TIM HOLTON

WRITTEN REPRESENTATION

HIGHWAYS ENGLAND'S RESPONSE

ADDITIONAL COMMENTS FROM TIM HOLTON

Drawing file: TR010019 / TR010019-003722-Environmental Masterplan Sheet 4.pdf

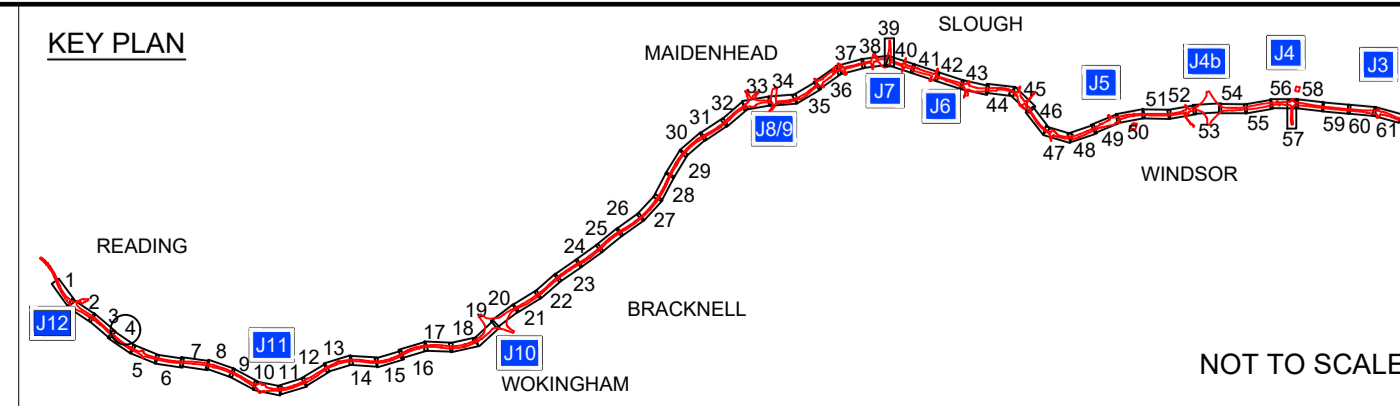
- 1.1 *Talking with my fellow Wokingham Borough Councillor Norman Jorgensen I have been informed you are requesting additional information as to areas which suffer from the excessive noise that the M4 currently produces. So as a further submission I would like to mention Cutbush Lane; Red house Close; Manea Close; Wimblington Drive; Bottisham Close; Wild Close; Harlton Close; Gregory; Bassett Close; Whitcham; Paddick Drive; Chesterment Way; Swanmore Close; Edenham Close.*
- 1.2 *I personally live on Toseland Way which has numerous roads between us and the M4. During the summer it can be tough call between the continual drone of the cars on the motorway and the heat if the window remains closed.*

- 1.2.5 Highways England confirms that the Earley / Lower Earley area was subject to the assessment undertaken as part of the enhanced noise mitigation study. The confirmed barrier provision in this area is detailed within Appendix E of the Enhanced Noise Mitigation Study Report (Ref 514451-MUH-00-ZZ-RP-EN-400158), sheets 4 and 5 are relevant to the Early / Lower Earley area.

- 1.2.6 The results of the enhanced noise mitigation study show that an additional 2126 metres of 2.5 metre high noise barrier will be provided adjacent to Lower Early and an increased length of 297m of new barrier will be provided in the Mill Lane

area. The provision of this mitigation will provide further noise decreases to properties in Lower Earley, in addition to those presented in Sheet 4 and 5 of Drawing 12.4 of the ES (which showed minor noise decreases across Lower Earley on Scheme opening, without this enhanced mitigation).
